City of Albuquerque

February 9, 1993

RE: DRAINAGE PLAN FOR PLACITA DE ABOGADO (J14-D88A) ENGINEER'S STAMP
DATED 2/2/93.

**GRADING & DRAINAGE PLAN**  
**PLACITA de ABOGADO**  
**RON A. BELL**  
 SEVENTH ST. & FRUIT AVE. N.W.  
 ALBUQUERQUE, NEW MEXICO

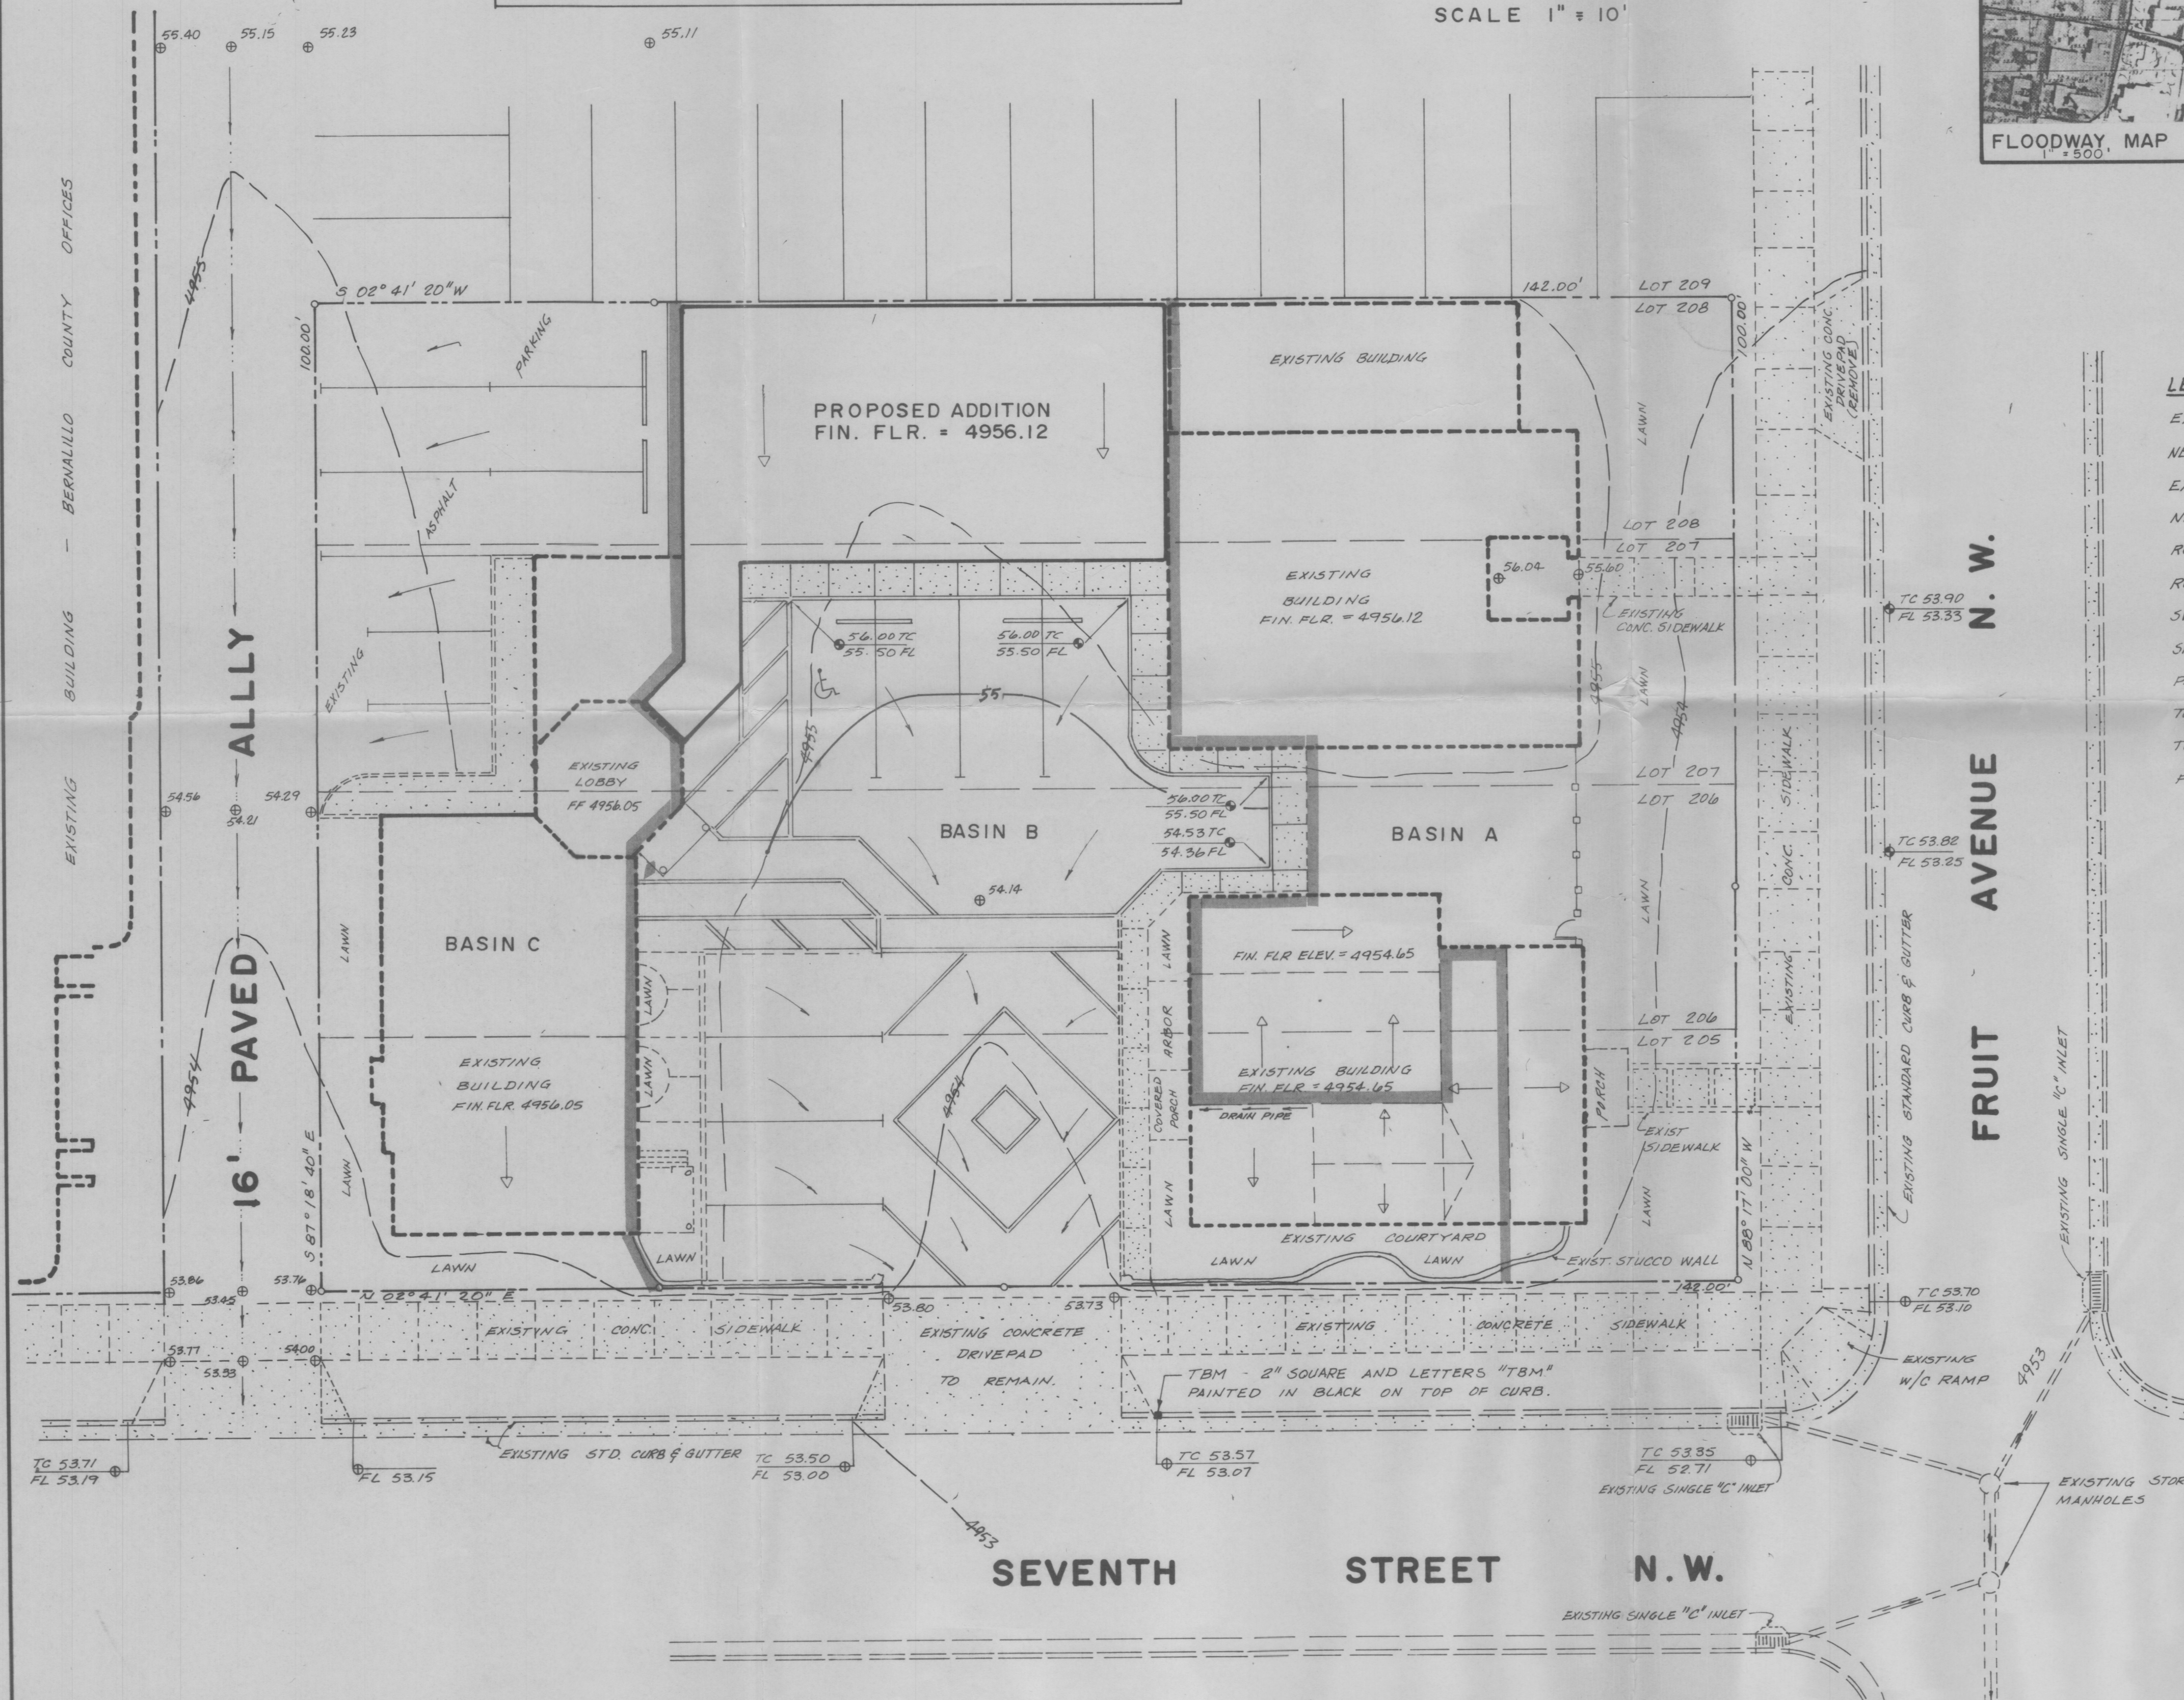
1. Cross lot-line drainage easement will be required for drainage from lot 207 thru 206. Cross-lot-line drainage for other lots will not be required because they straddle the buildings.
2. Please identify where the roof run-off from the newly constructed addition is being routed to . If it is routed onto lot 209, then permission from the adjacent property owner will be required, or provision must be made to route it within lot 208.
